From: [Redacted]
Sent: Thursday, 8 December 2016 12:23 PM
To: Petra Blumkaitis
Subject: RE: Development Referral - 23-33 and 35-39 Bridge Street, Sydney (SSD 7484 and 6751)

Thank you for referring the application to **modify the Sandstone Precinct to Sydney Water**.

Drawing No.	NSW16-02-01	Rev.	0
-------------	-------------	------	---

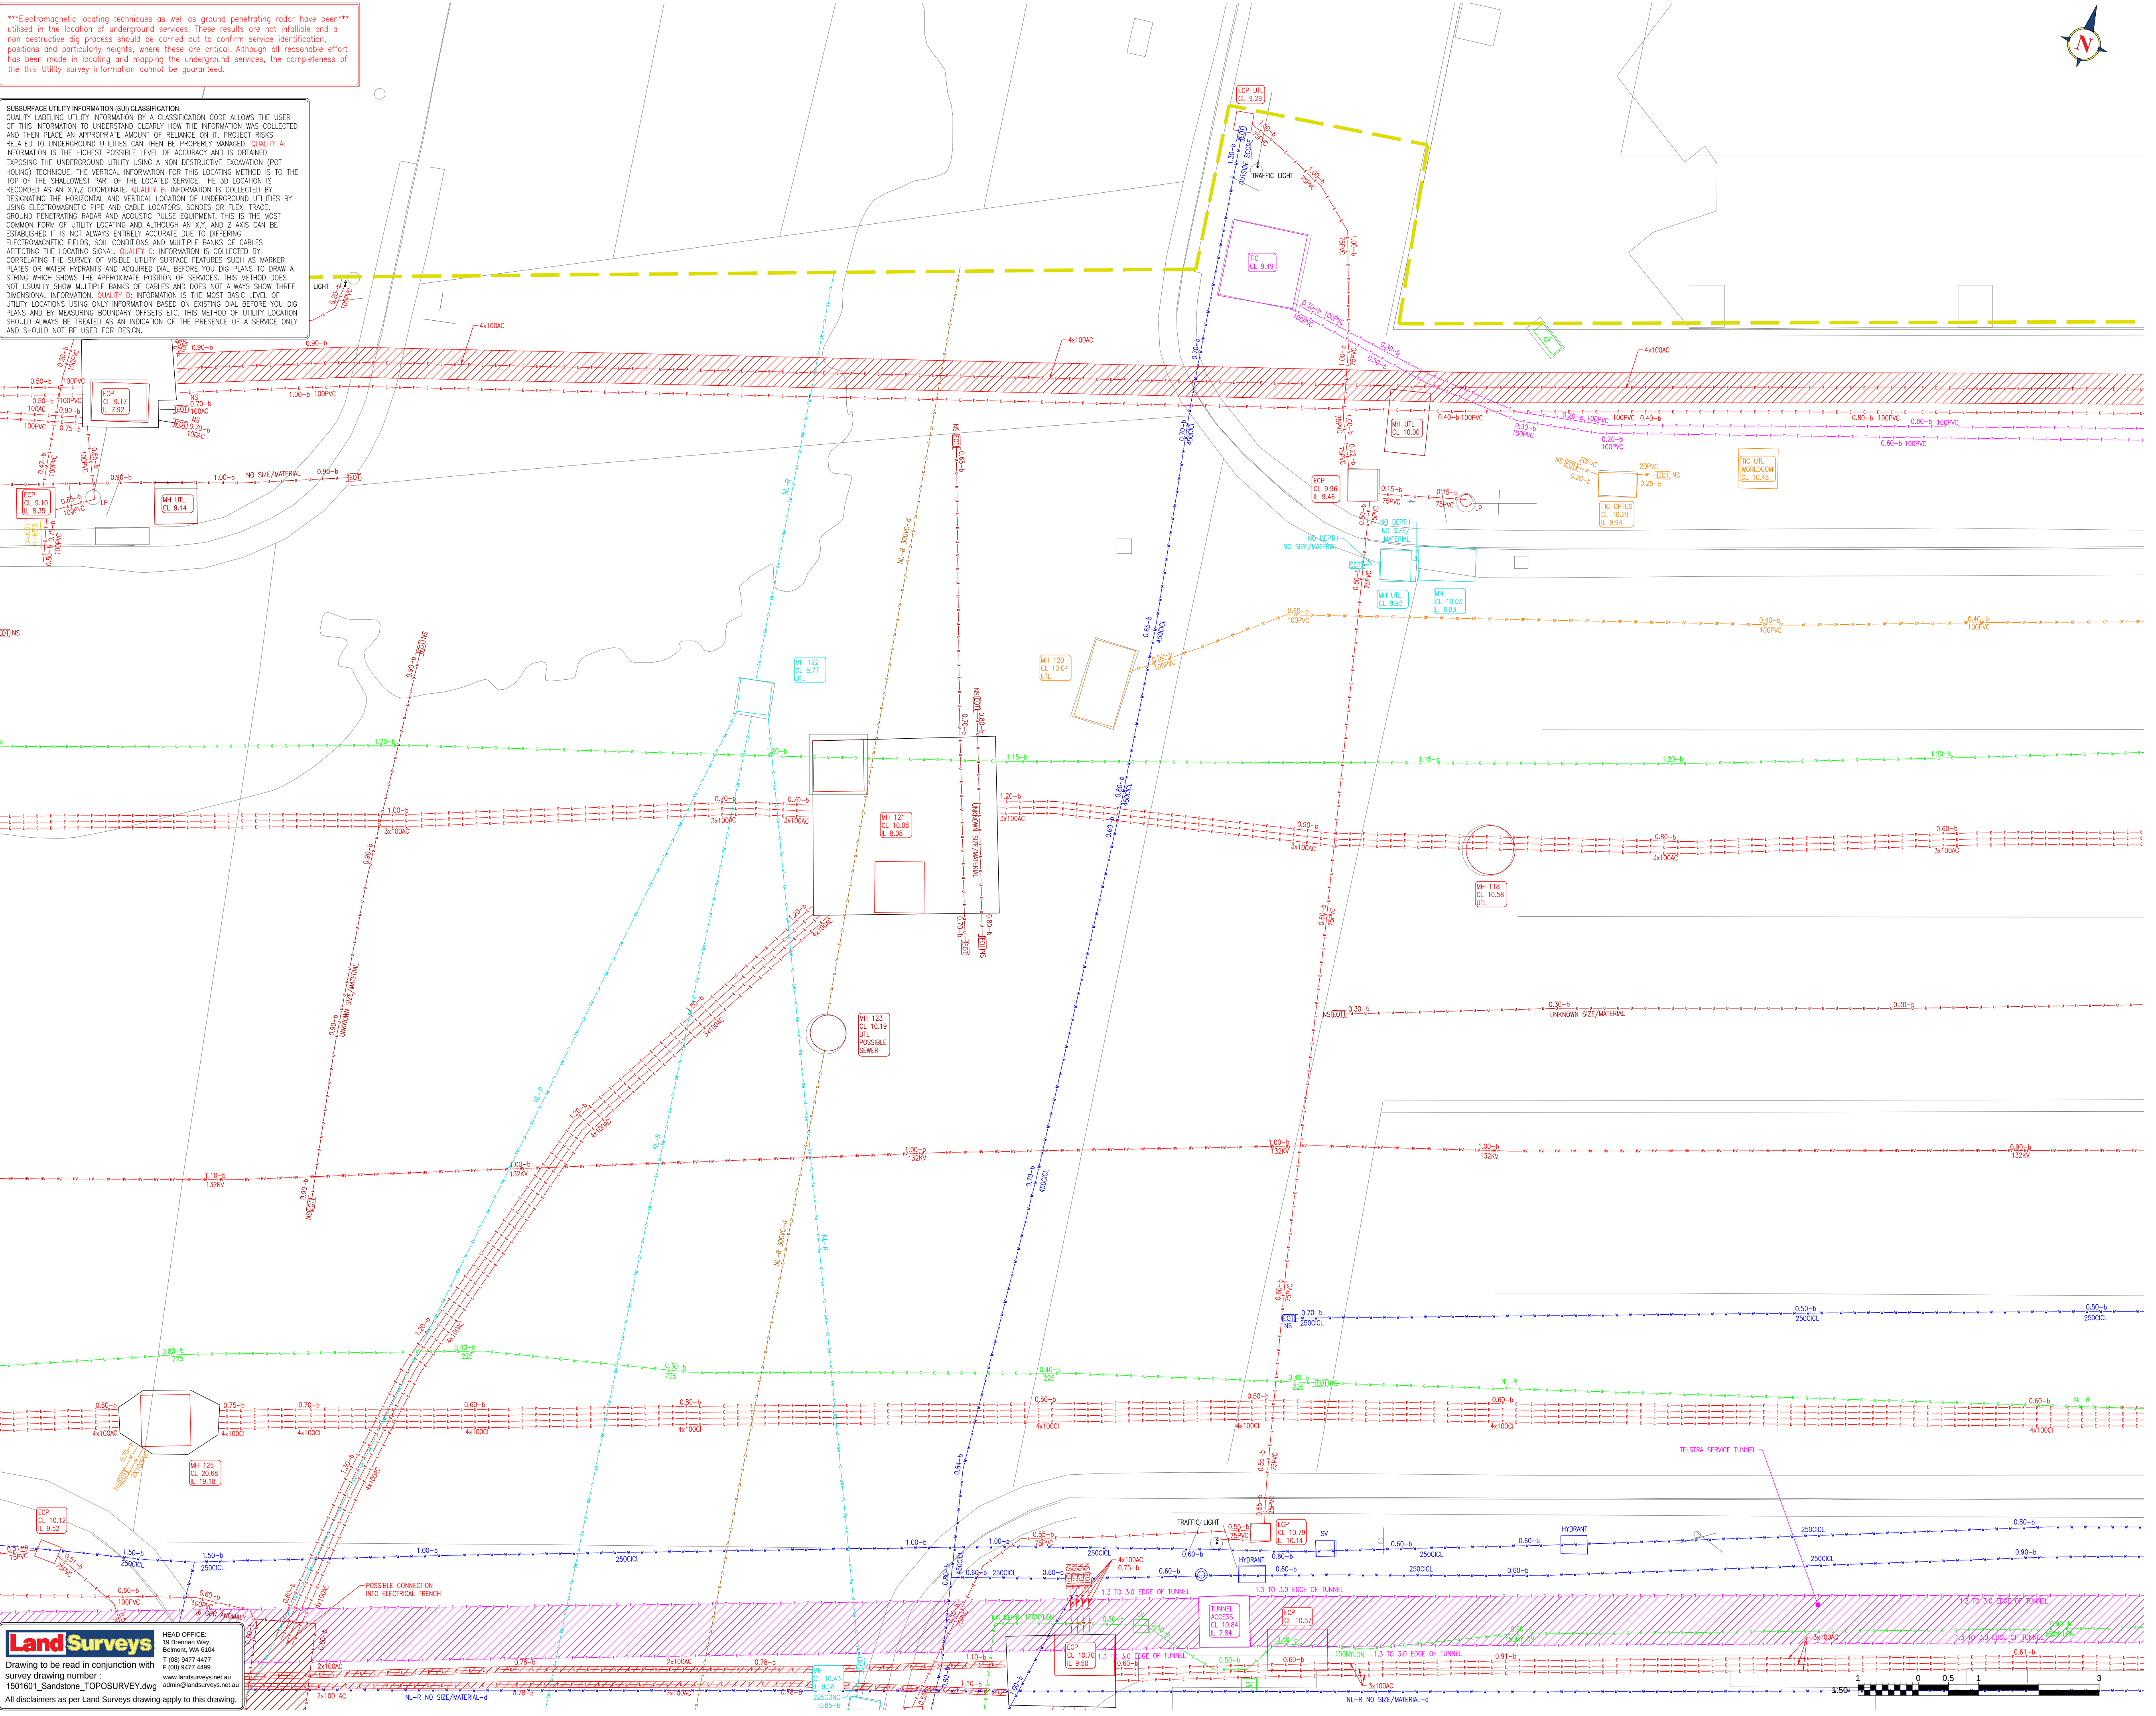
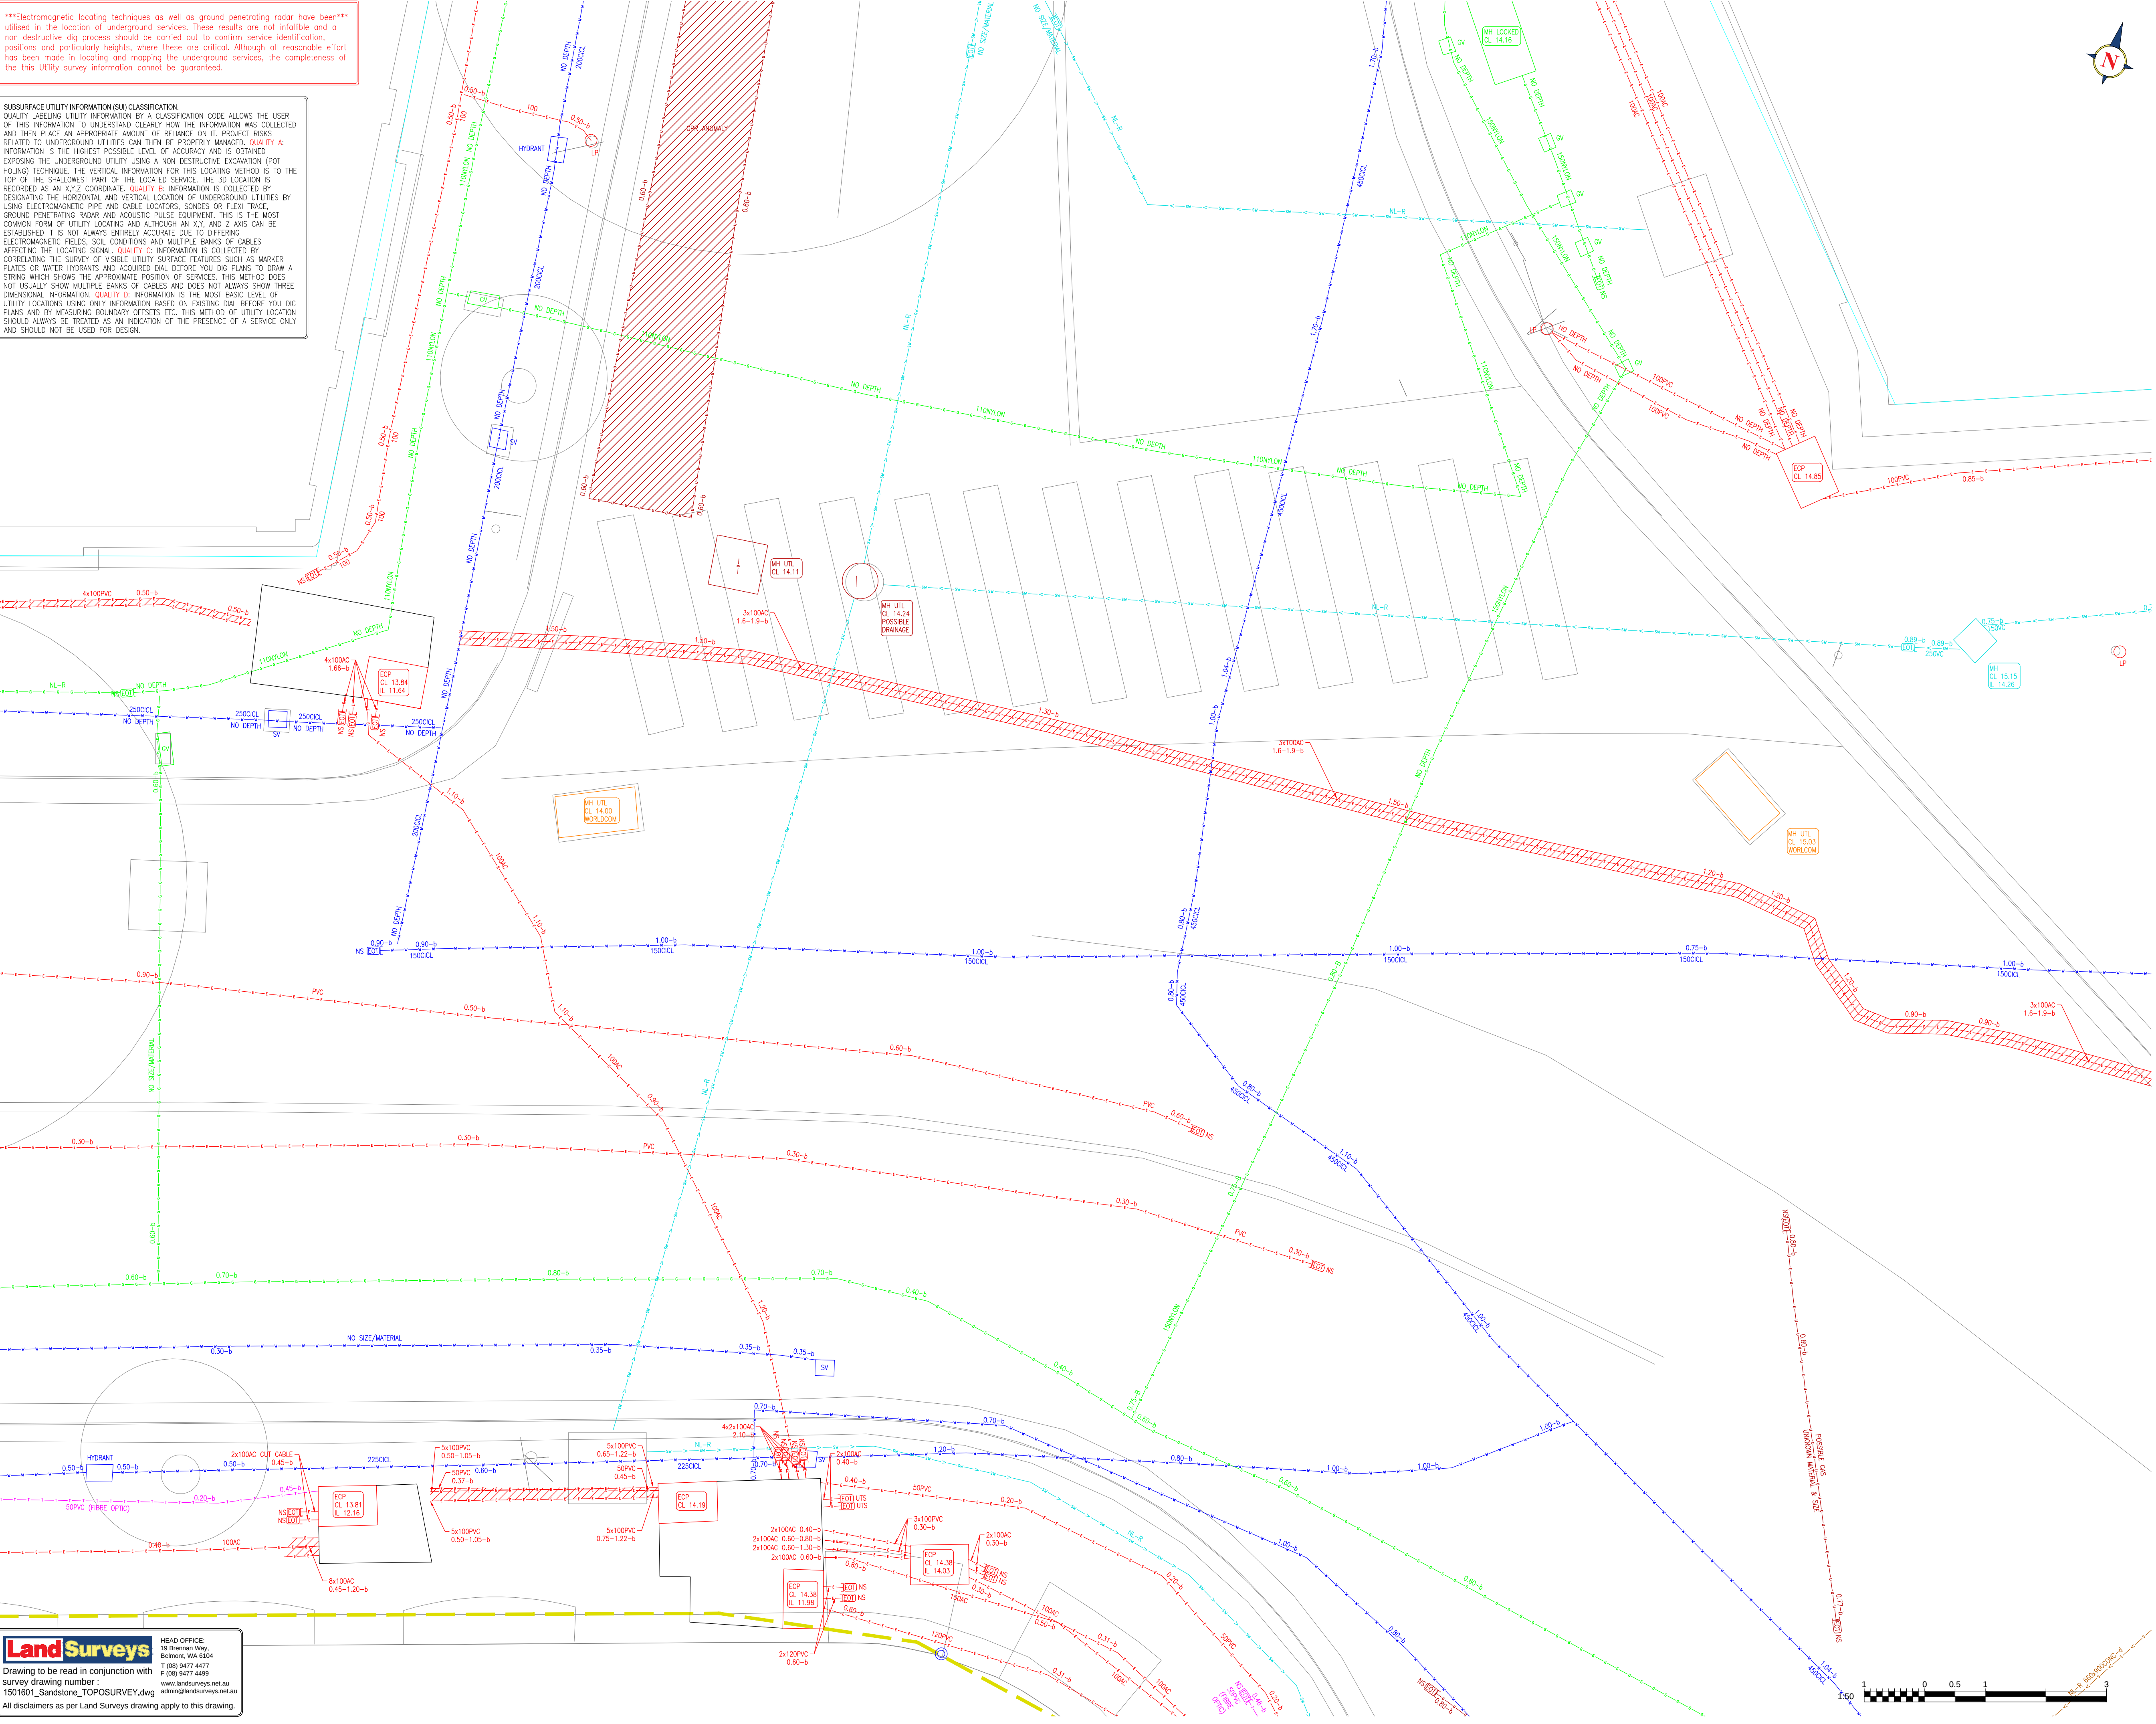
- There is insufficient information at this stage to provide advice on the proposed development
- There are several Sydney Water stormwater assets that may be impacted, particularly heritage. These must be identified and addressed.

- **City Area 29**
- Castlereagh St, stormwater branch- Oviform 711x1070 brick
- Pitt St, stormwater branch -300mm Concrete

Sydney Water’s guidelines for constructing buildings over or adjacent to stormwater assets outline the process and design requirements for such activities. As per the guidelines, the applicant is advised of the following:
No building or permanent structure is to be constructed within 1m from the outside wall of the stormwater asset.
